**WEST SUSSEX COUNTY COUNCIL
INFRASTRUCTURE CONSULTATION**

SUBJECT: WA/90/10-COU of store to single dwelling with porch extension and additional window to north & west elevations and to east facing roof slope.

Walberton House, The Street, Walberton, West Sussex, BN18 0PJ

BLOCK/SITE PLAN
FOR NICKI SHALE-HESTER

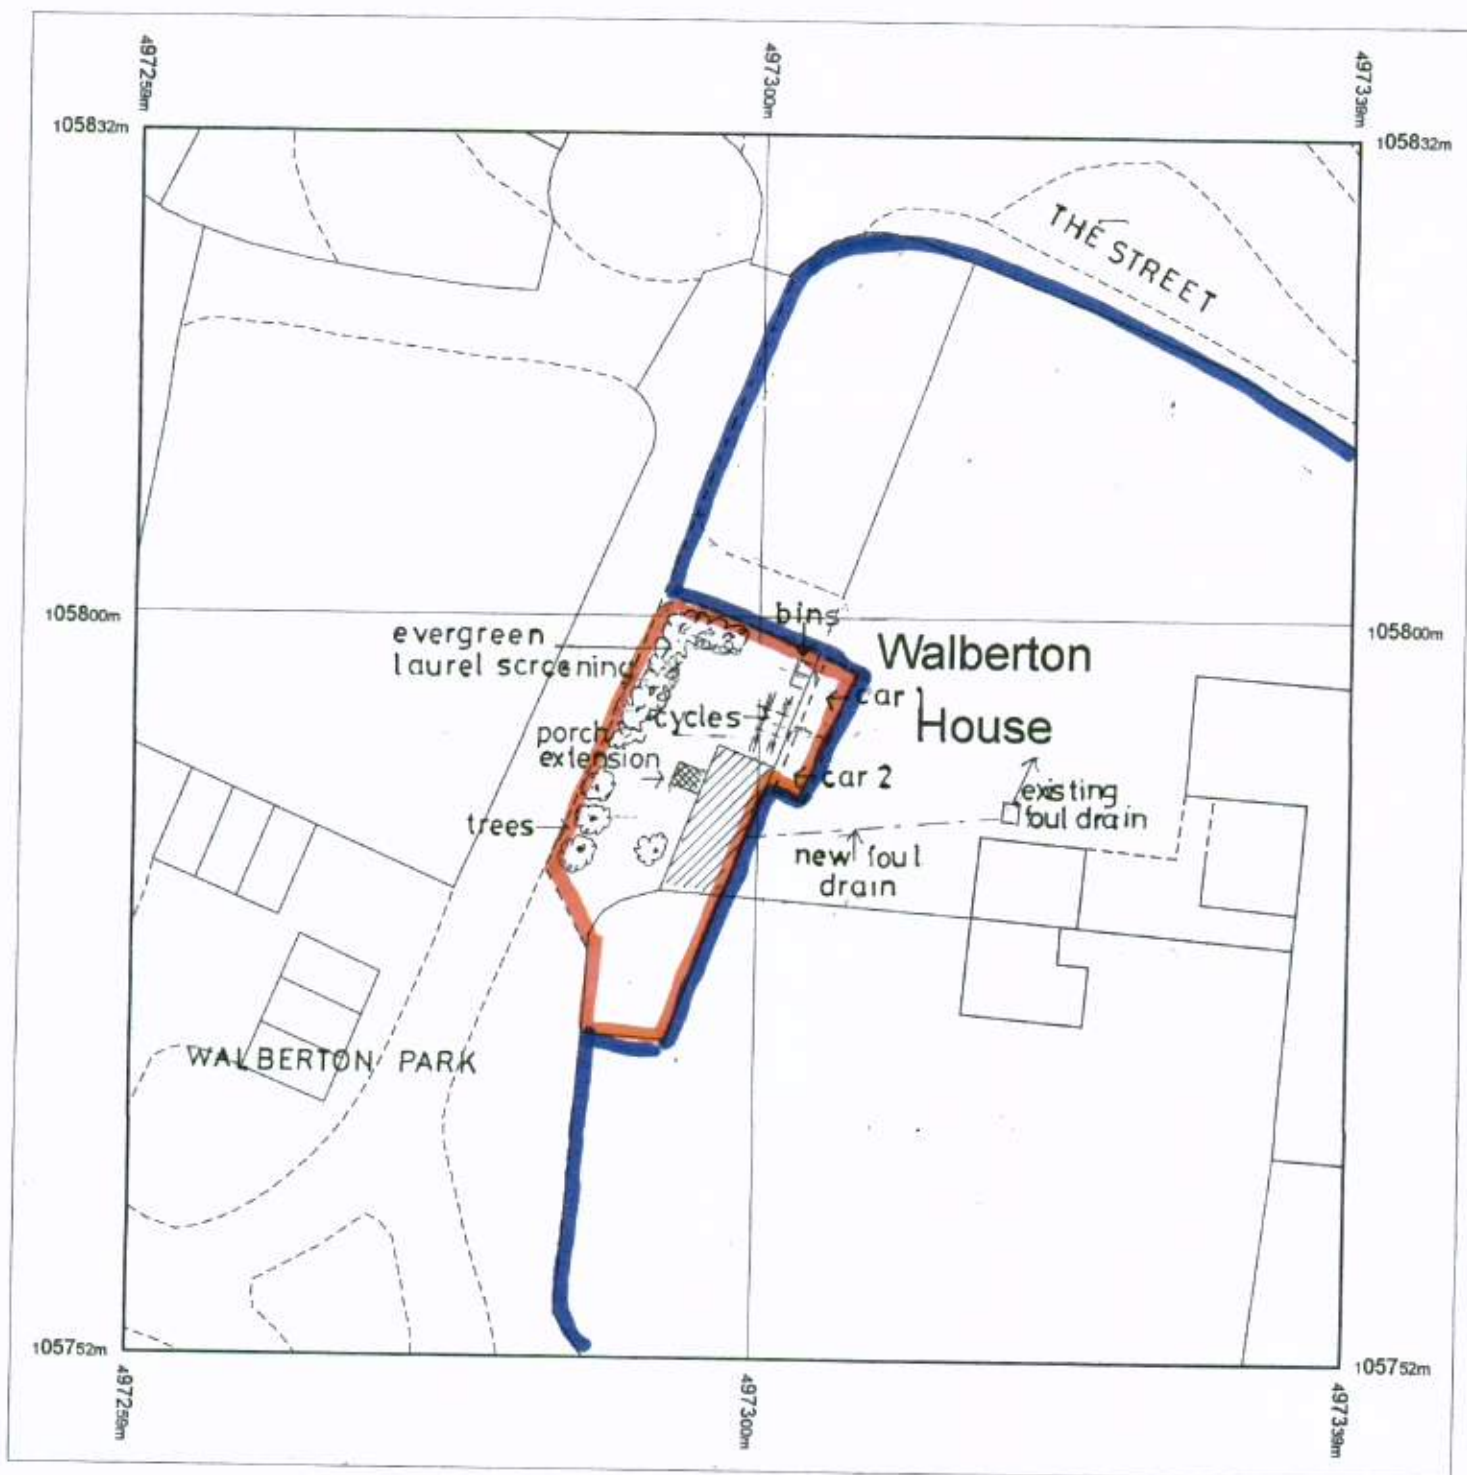
It would be beneficial for details of the car parking to be confirmed to demonstrate that satisfactory car parking arrangements can be provided. On the basis that three spaces are proposed, this considered appropriate, and no highway safety concerns would arise through this provision. The Planning Authority may wish to consider the implications of this proposal upon on-street car parking.

Cycle parking should be included however; this must be secure, covered and be capable of storing at least one cycle per bedroom of the proposed dwelling. The actual details of the cycle parking facilities should be submitted to and approved by the Local Planning Authority (LPA). To accommodate cycle parking it would be recommended that any cycle store should have minimum dimensions of 2m x 1m.

If the LPA are minded to approve this application a condition securing cycle parking should be included.
